From: Lisa Coney on behalf of Planning
Sent: 06 February 2017 08:54
To: Planning Scanning; Planning.Responses
Subject: FW: Planning Application FG/198/16/PL - OBJECTION - 1, Sea Drive, Ferring

Sent: 05 February 2017 13:45
To: Planning
Subject: Planning Application FG/198/16/PL - OBJECTION - 1, Sea Drive, Ferring

My name is Mrs Janice Royle of 108 Sea Lane, Ferring, West Sussex. This is the adjoining property in respect of the proposed development above.

TITLE: PROPOSED PLANS

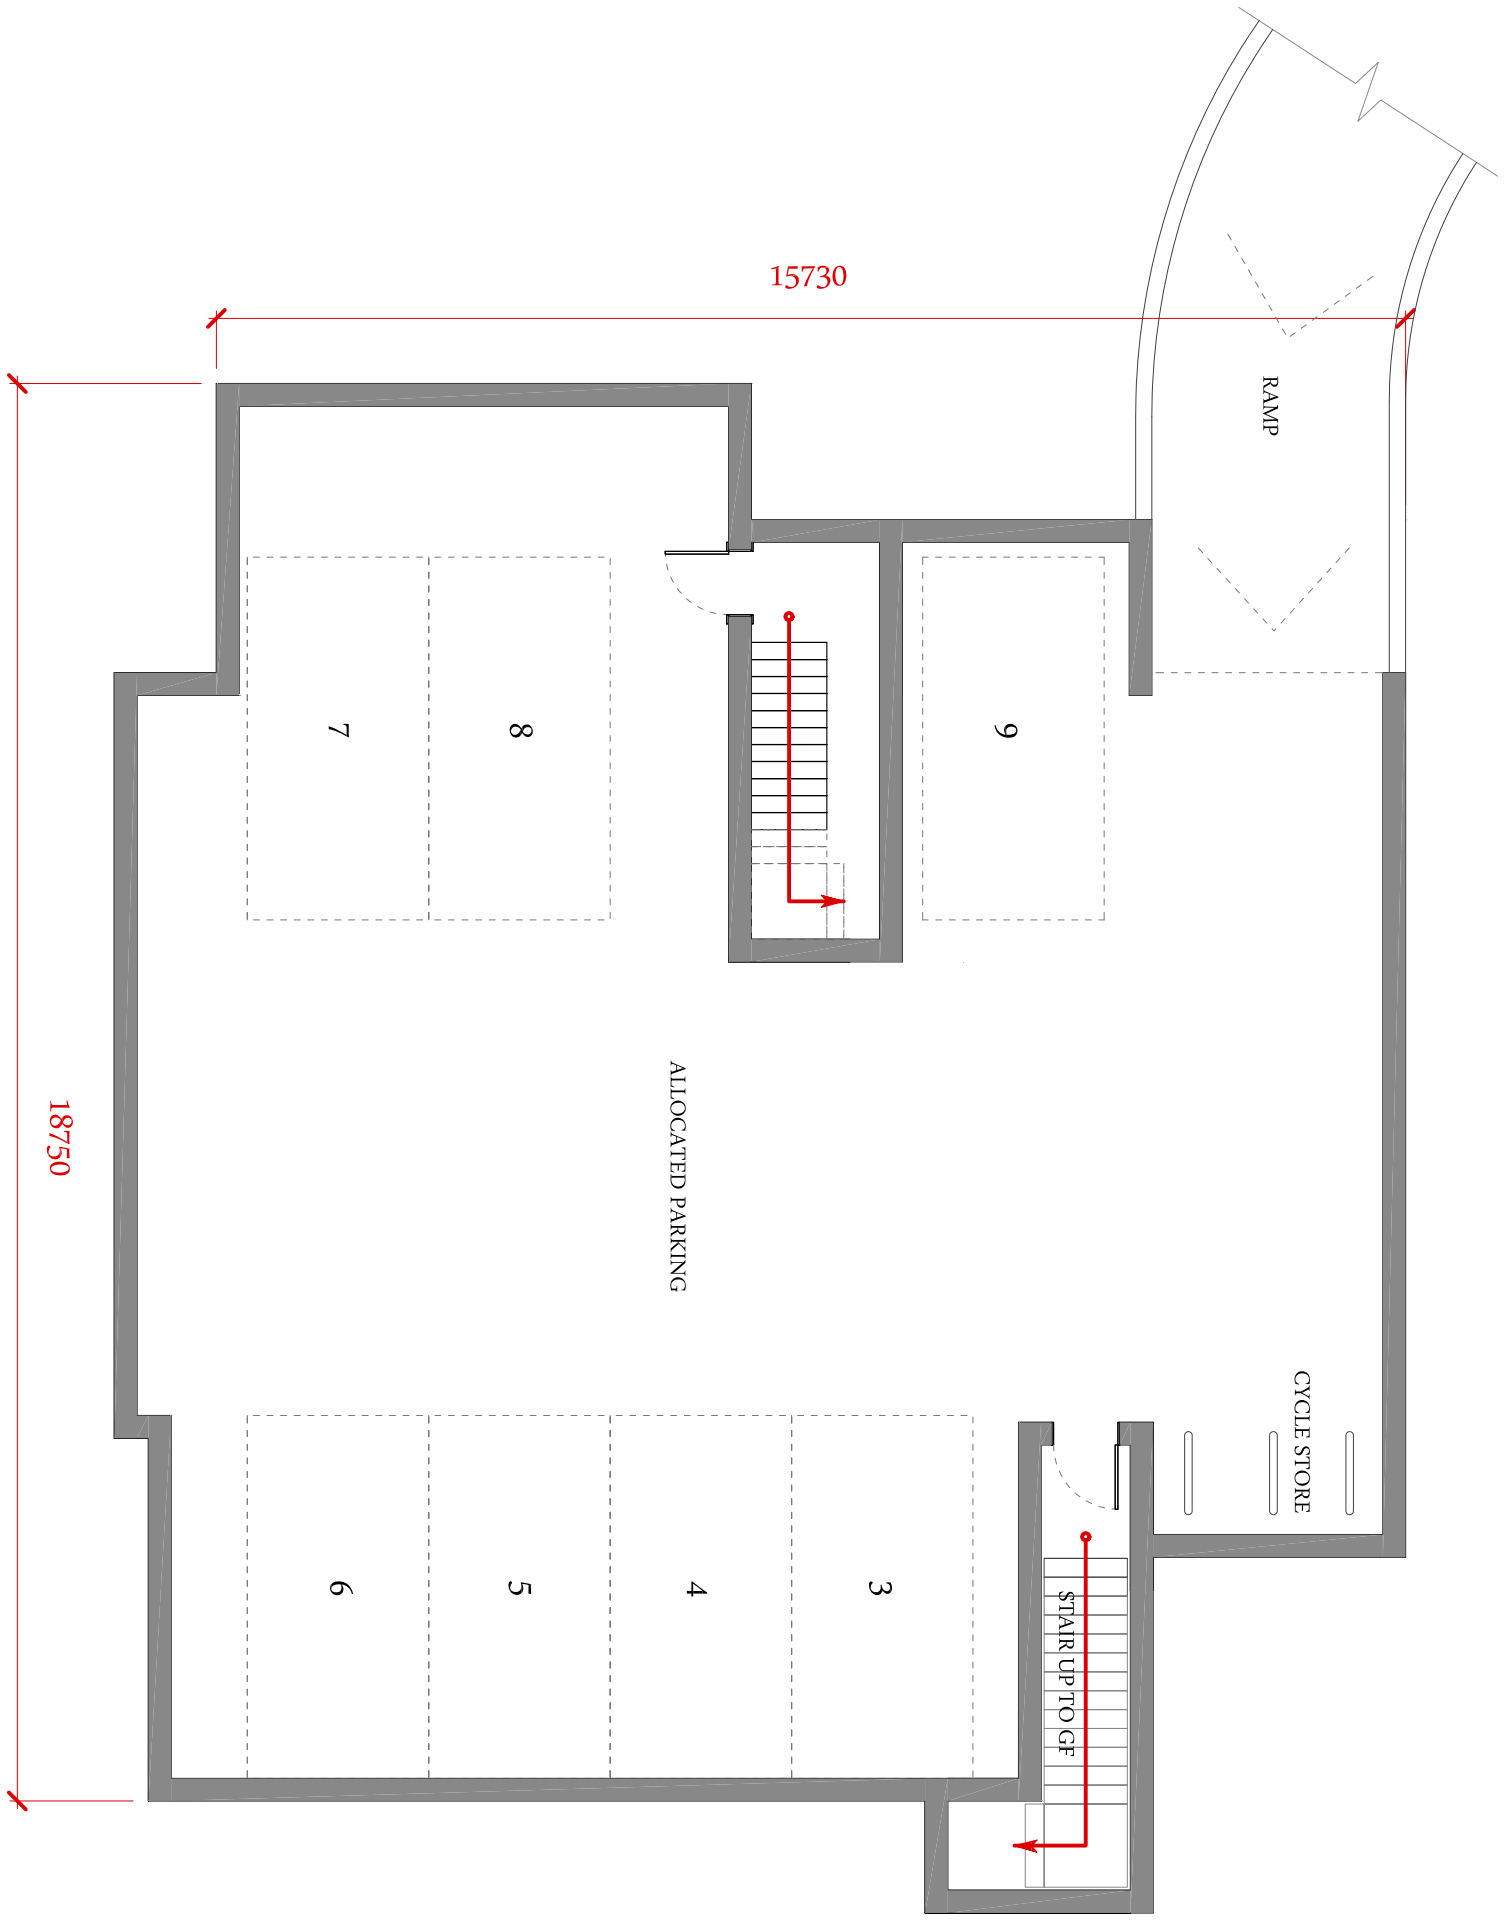
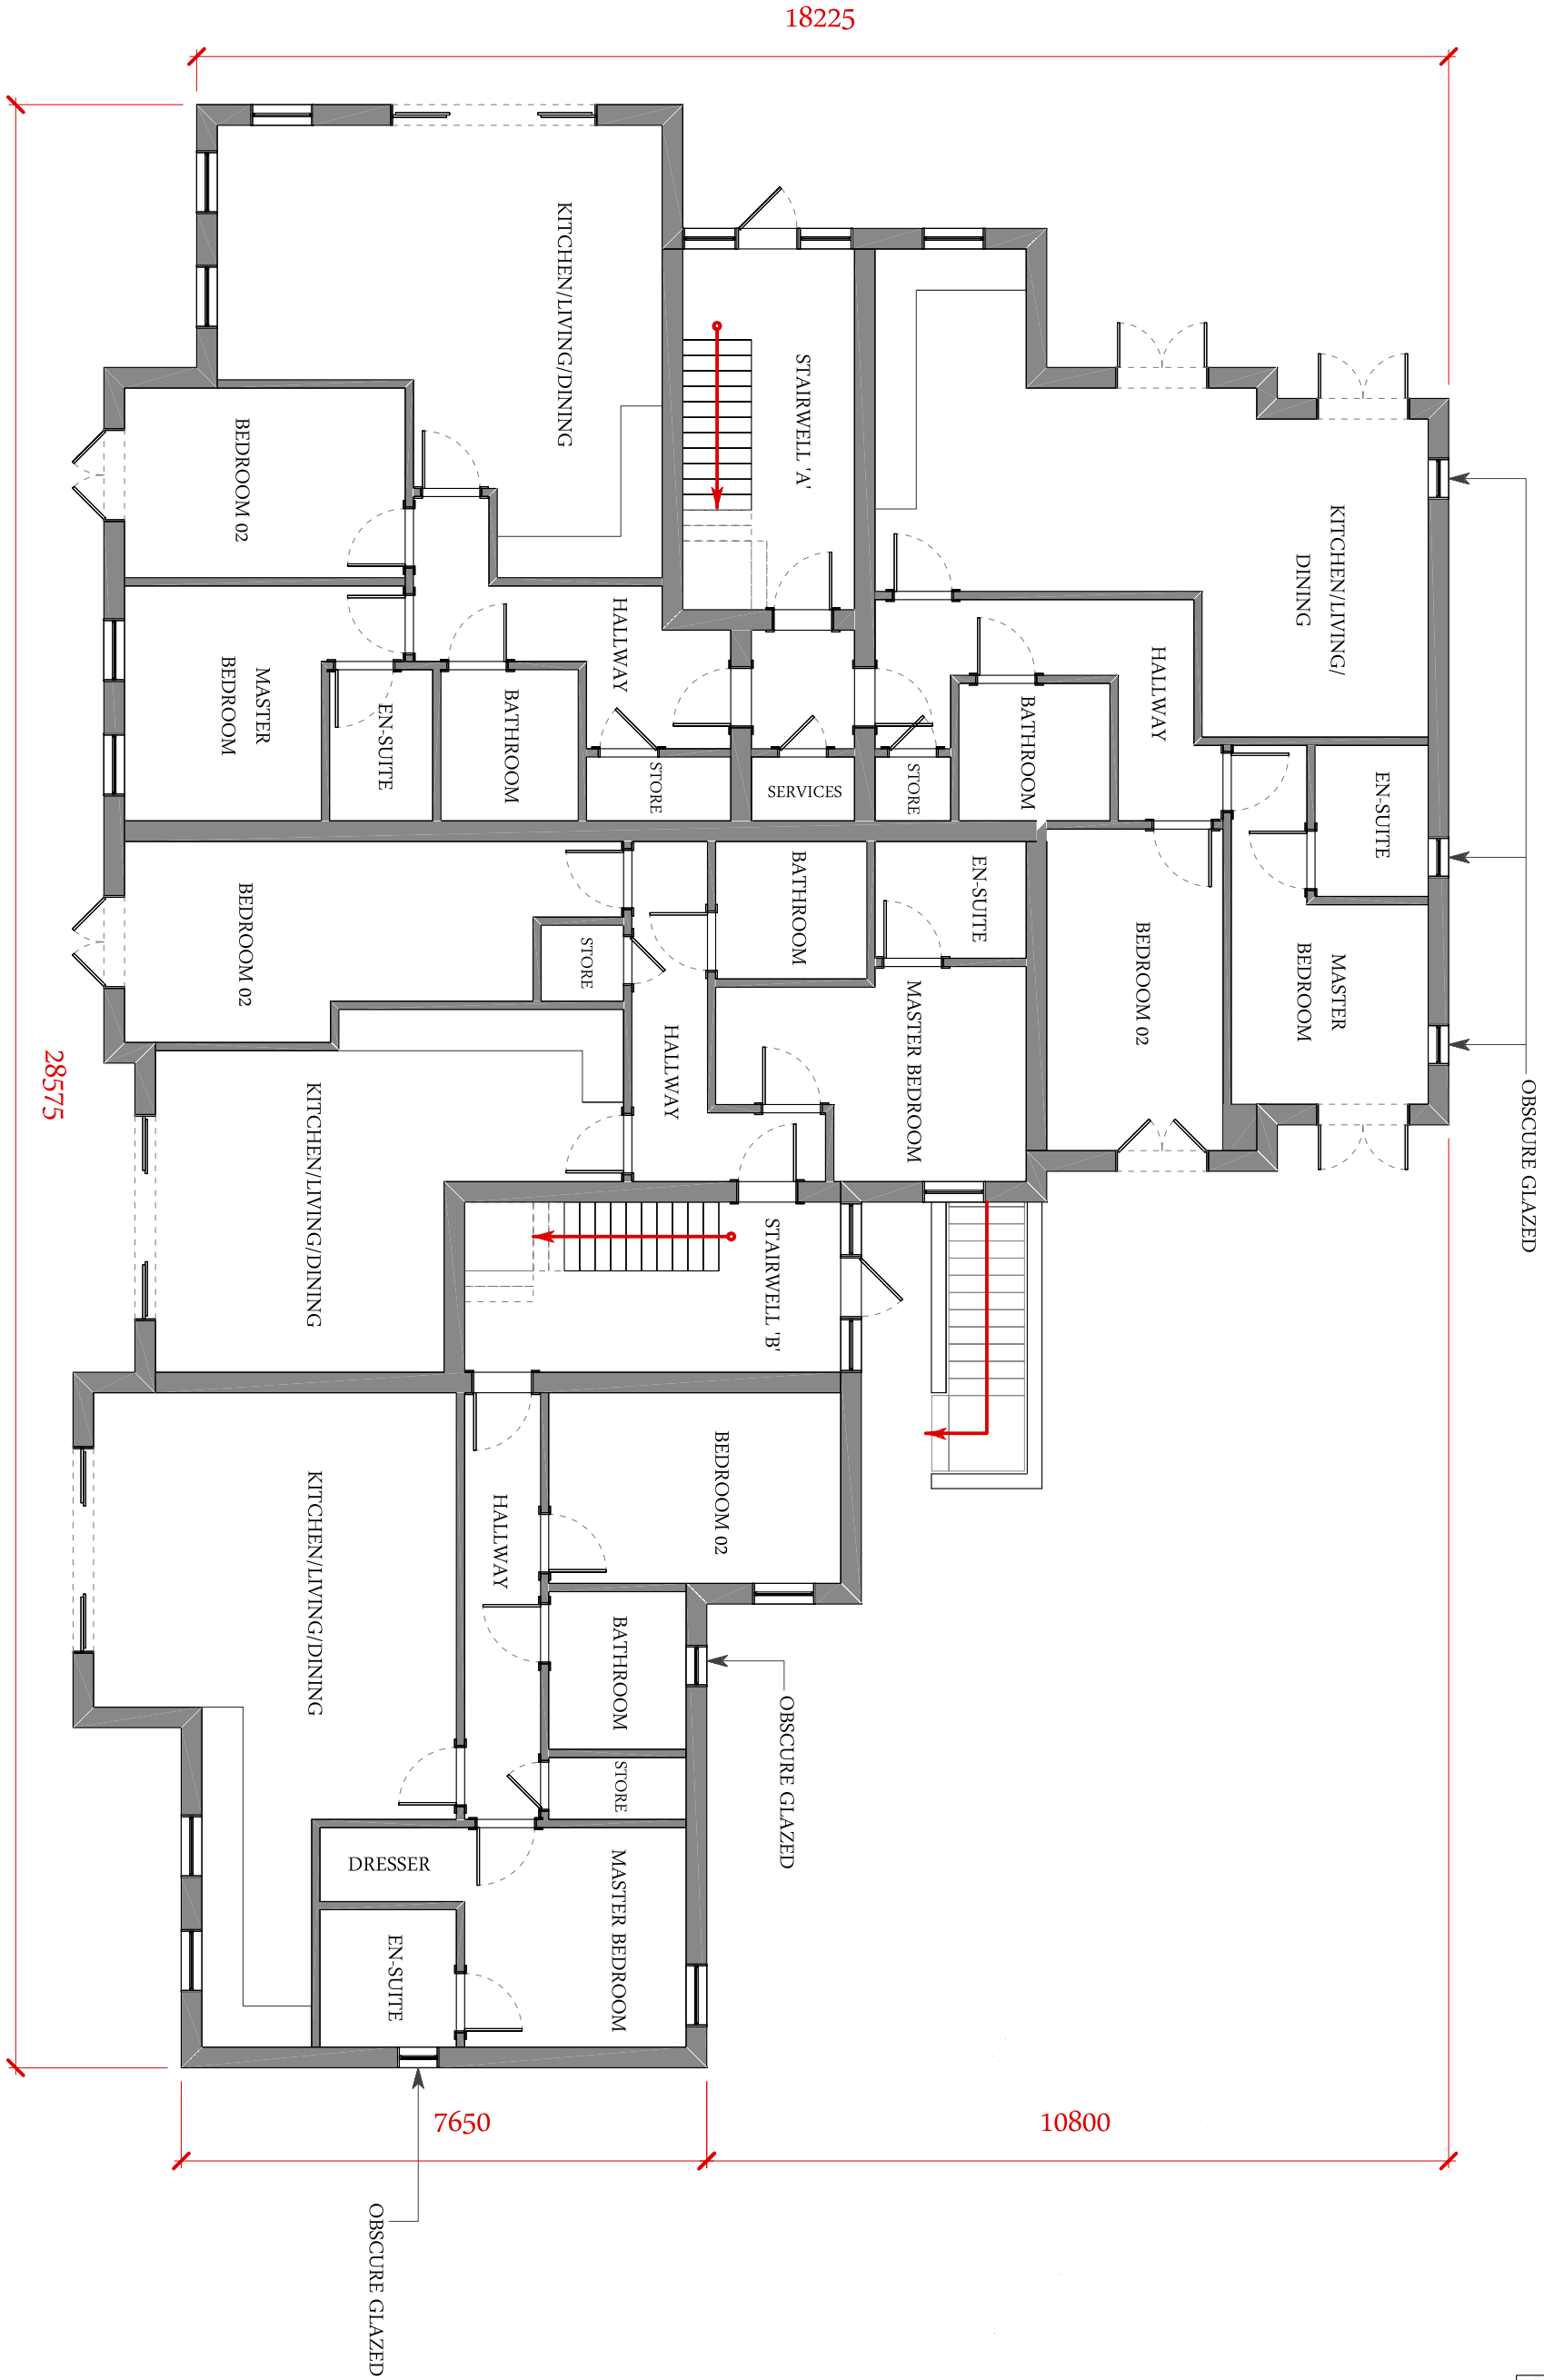
It is not in any way acceptable for the proposed construction to have a Master Bedroom window directly in line with my primary bedroom window where I spend a significant amount of my time. I vehemently object to this being the case.

I absolutely and most strongly object, to motor vehicles and motor bikes (for which provision has been made in said application) coming and going all hours of the day, and with headlights at night on full beam, directly under my bedroom window.

I strongly object to the proposal of a Bin Store under my main bedroom window and in close proximity to my lounge window and my rear doors.

I absolutely and utterly object to the ridiculous proposal of a new Highway Access onto Sea Lane, some three or four metres from my own driveway, on a complete blind spot.
